61 Mobbs Lane, Epping (Former Channel 7 Site)

**Modification to the car park layout for
Buildings 7 and 8 (MP 10_0158 MOD 6)**

Director-General's
Environmental Assessment Report
Section 75W of the
Environmental Planning and Assessment Act 1979

February 2013

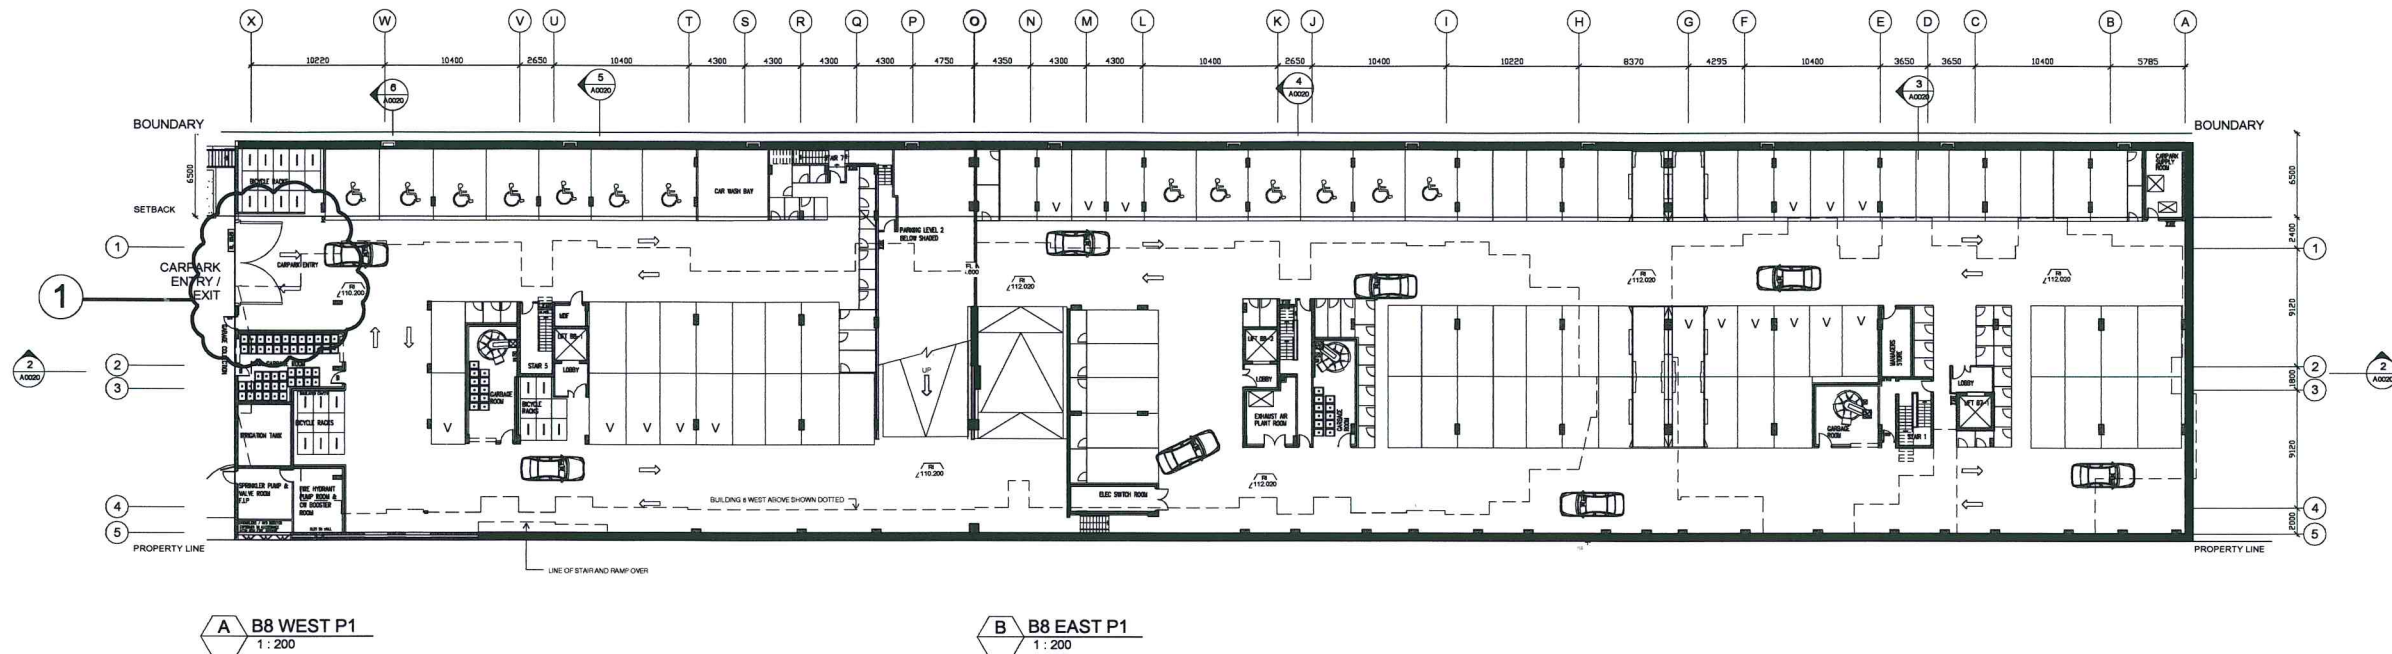
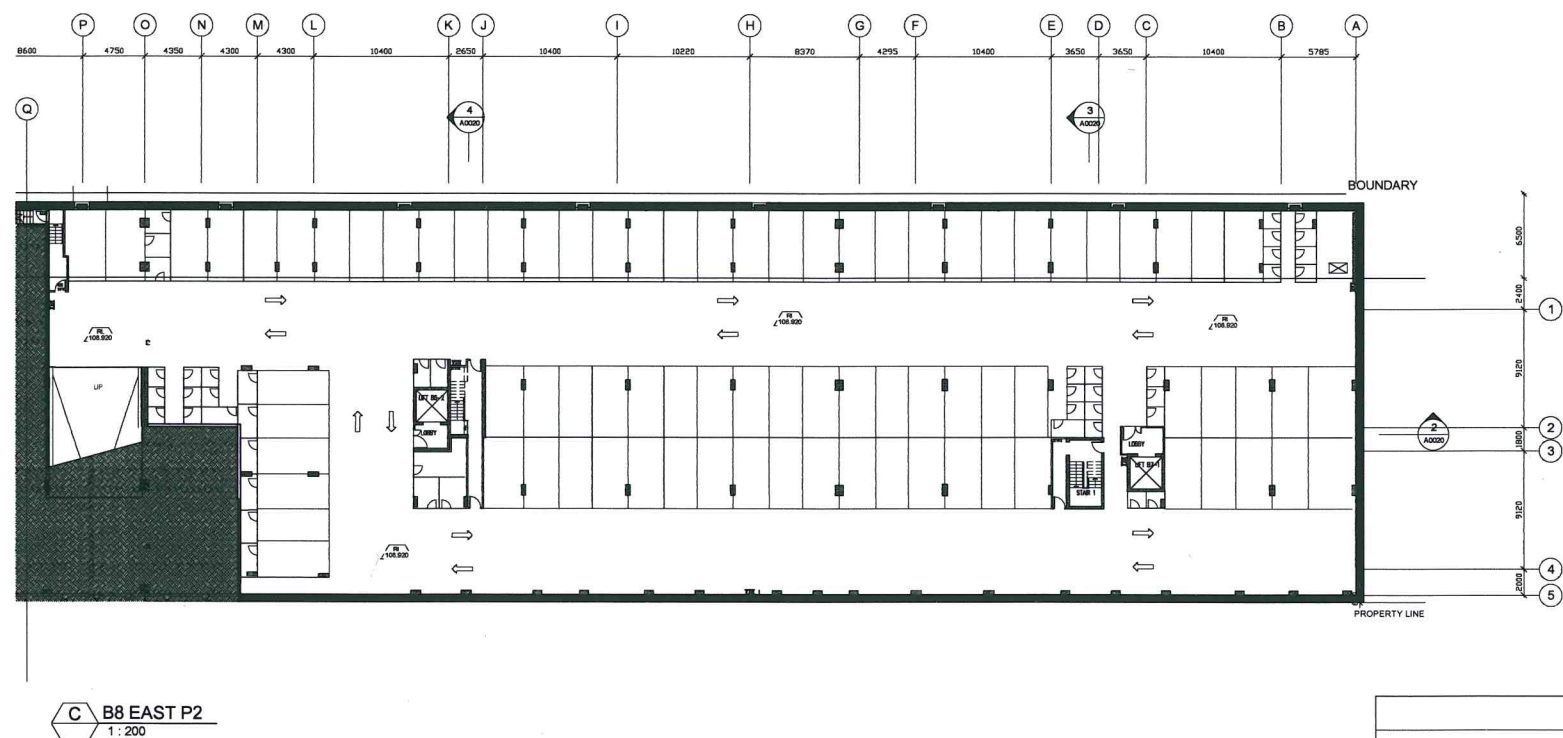
The proponent is seeking approval to relocate the car park entrance from the southern end of the western elevation of building 8 to the northern end of the western elevation. The proposed modification is sought to provide consistency with the car park entrance depicted in the elevation approved under MP10_0158 MOD 2 (**Figure 3**).

The approved plan indicates the car park entrance on the south of the western elevation for Building 8. As highlighted in section 2.1 **Figure 3**, the approved elevation of Building 8 shows the car park roller door to be located to the north of the western elevation for Building 8. The proposed entrance has been relocated to the north to allow for consistency with the approved elevation drawing.

The department considers the relocation of the car park entrance to the north to ensure consistency with the elevation drawing approved under MP10_0158 MOD 2 is appropriate, and will not result in any adverse traffic impacts. In addition, the proposed car park entrance caters for the topography on site to improve construction. As a result of the proposed relocation of the car park entrance, minor internal reconfiguration of service rooms and bicycle storage spaces will be necessary. The department considers these changes are minor and will not reduce the functional aspect of the car park.

The department therefore, considers the proposed relocation of the car park entrance to the north of the western elevation acceptable.

It is therefore recommended that the amended car park plan A0011C be approved as outlined in the recommended Instrument of Modification Approval.
